**Objection to the proposed Valley Of The Winds Wind Farm project - State Significant Development Application - SSD-10461**

This is an objection to the proposed Valley Of The Winds (“VOTW”) Wind Farm project (“Project”) following review of the published Environmental Impact Statement (“EIS”). It is submitted that the proposed Project should be either refused or abandoned. Failing that, the Project should be refused in its current form, significantly revised and re-exhibited.

# Revised Shadow Flicker Diagram

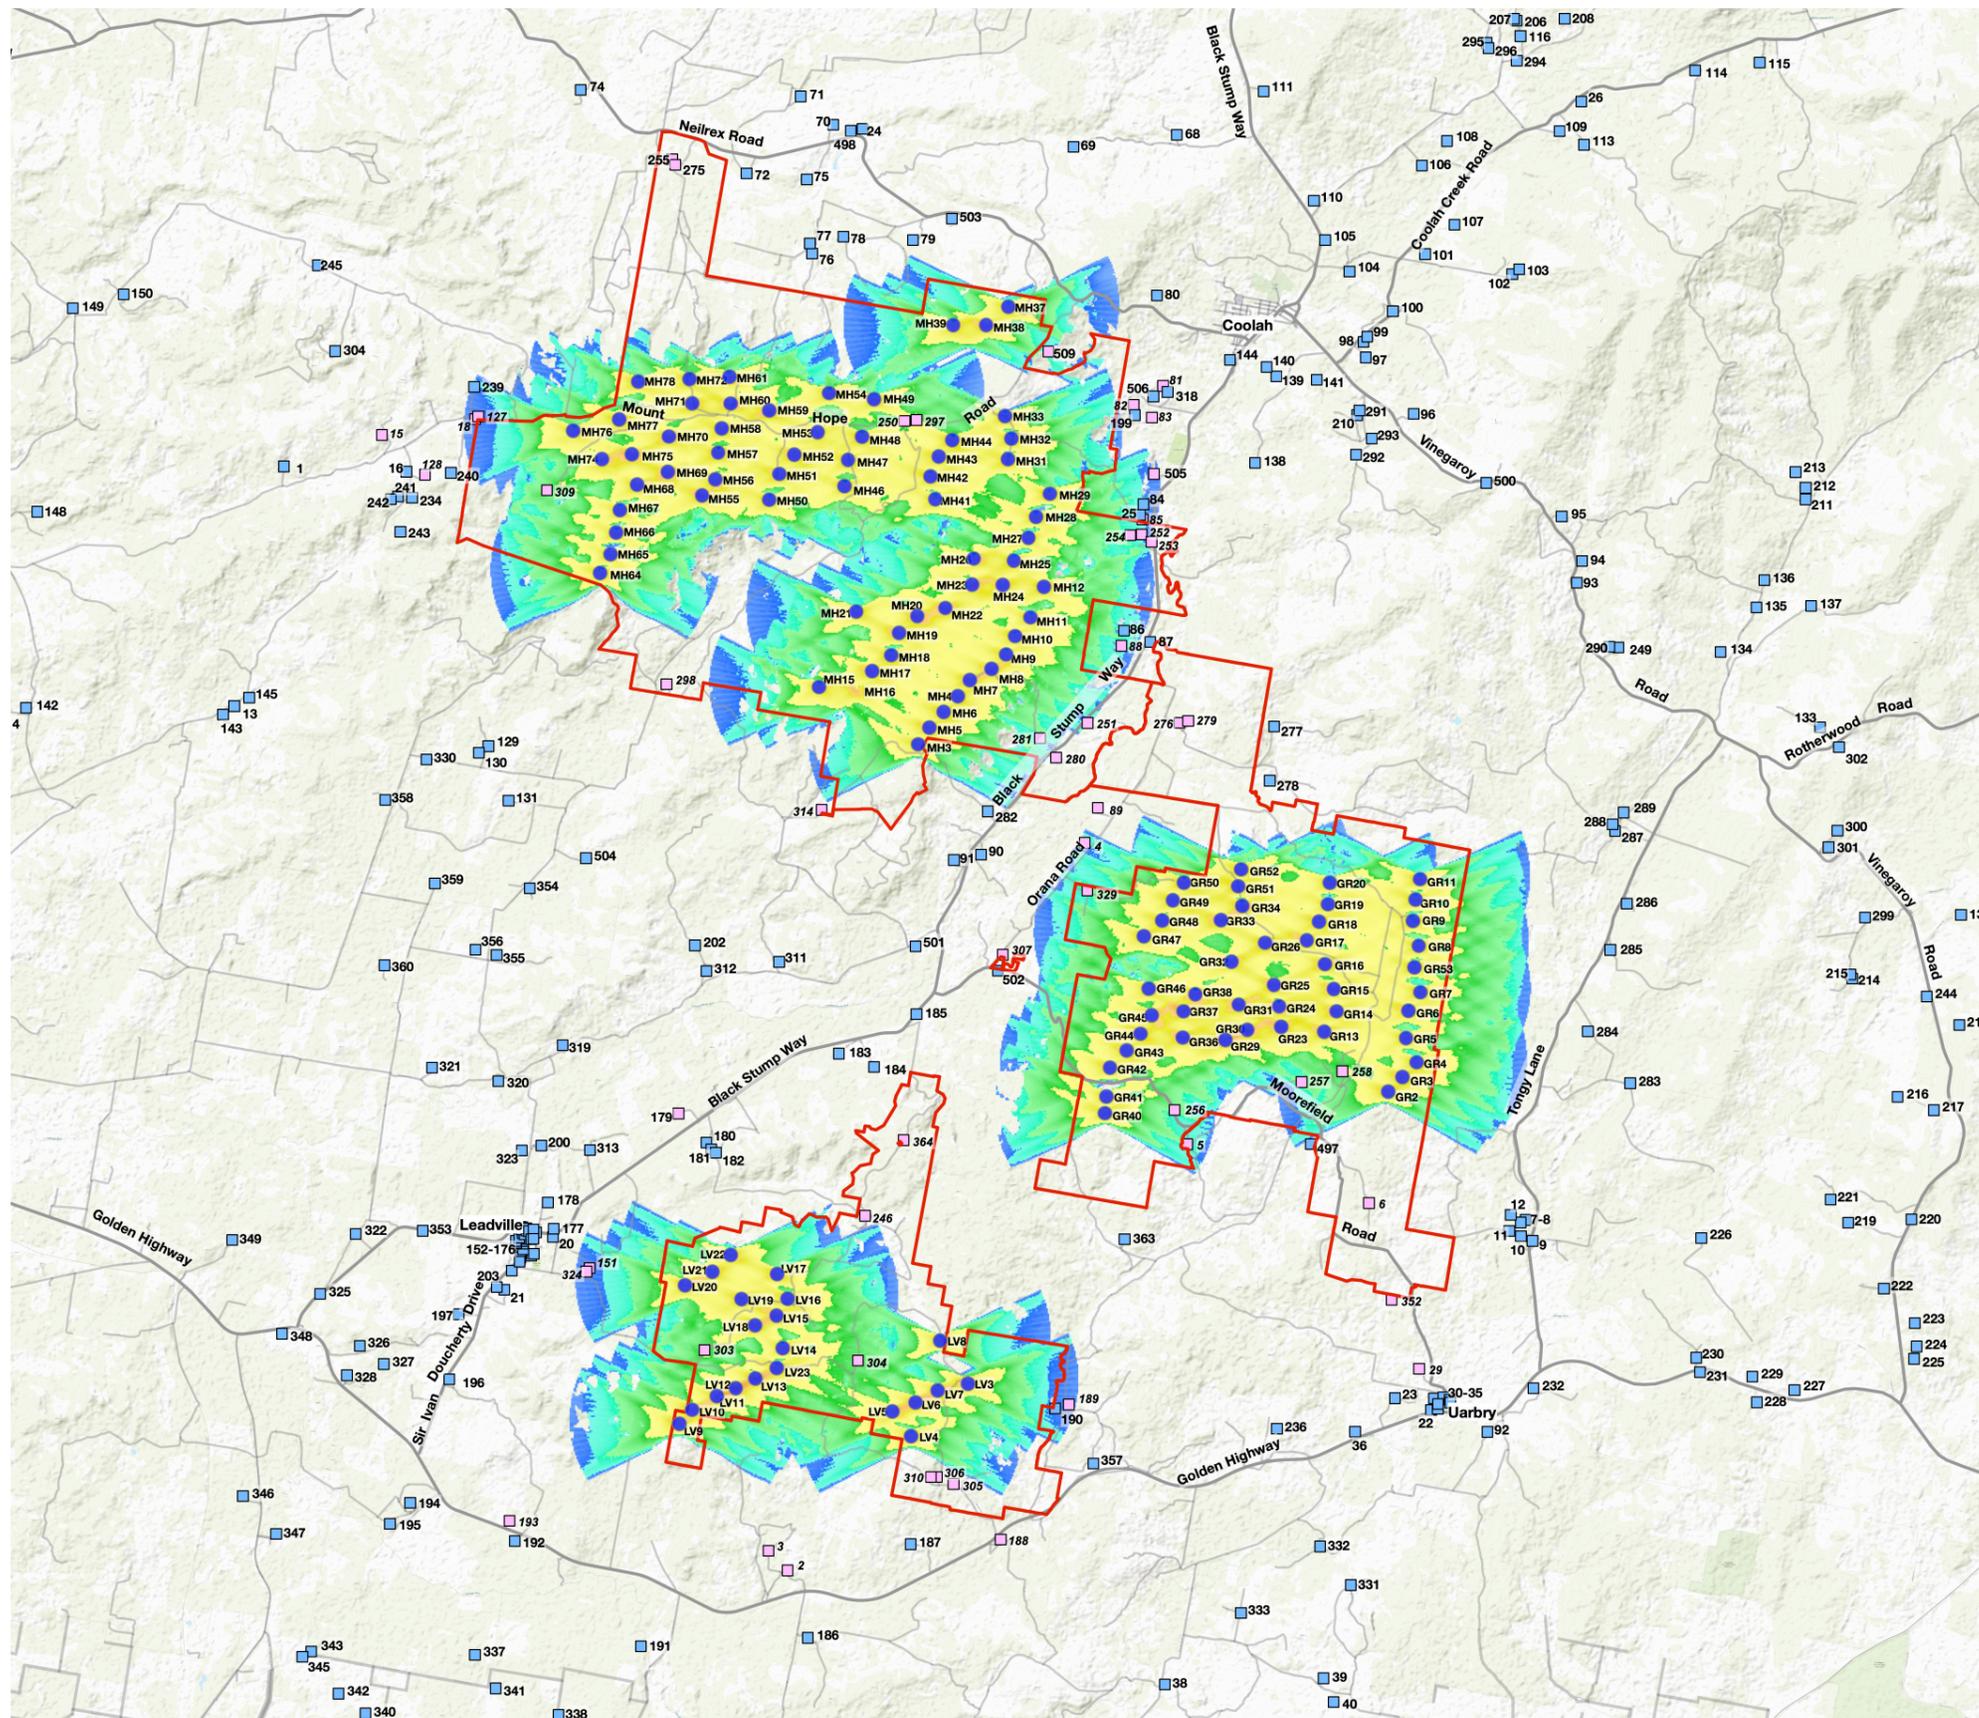
- The shadow flicker impact across the Turee Creek valley including large swaths of Tongy have not been adequately assessed. Moving and handling livestock which risk being impacted by shadow flicker is unacceptable and potentially unsafe for employees. Given turbine heights will exceed 350m across the adjacent Turee Creek Valley floor, the shadow flicker impact will well exceed the 30 hours per year stated in the EIS.
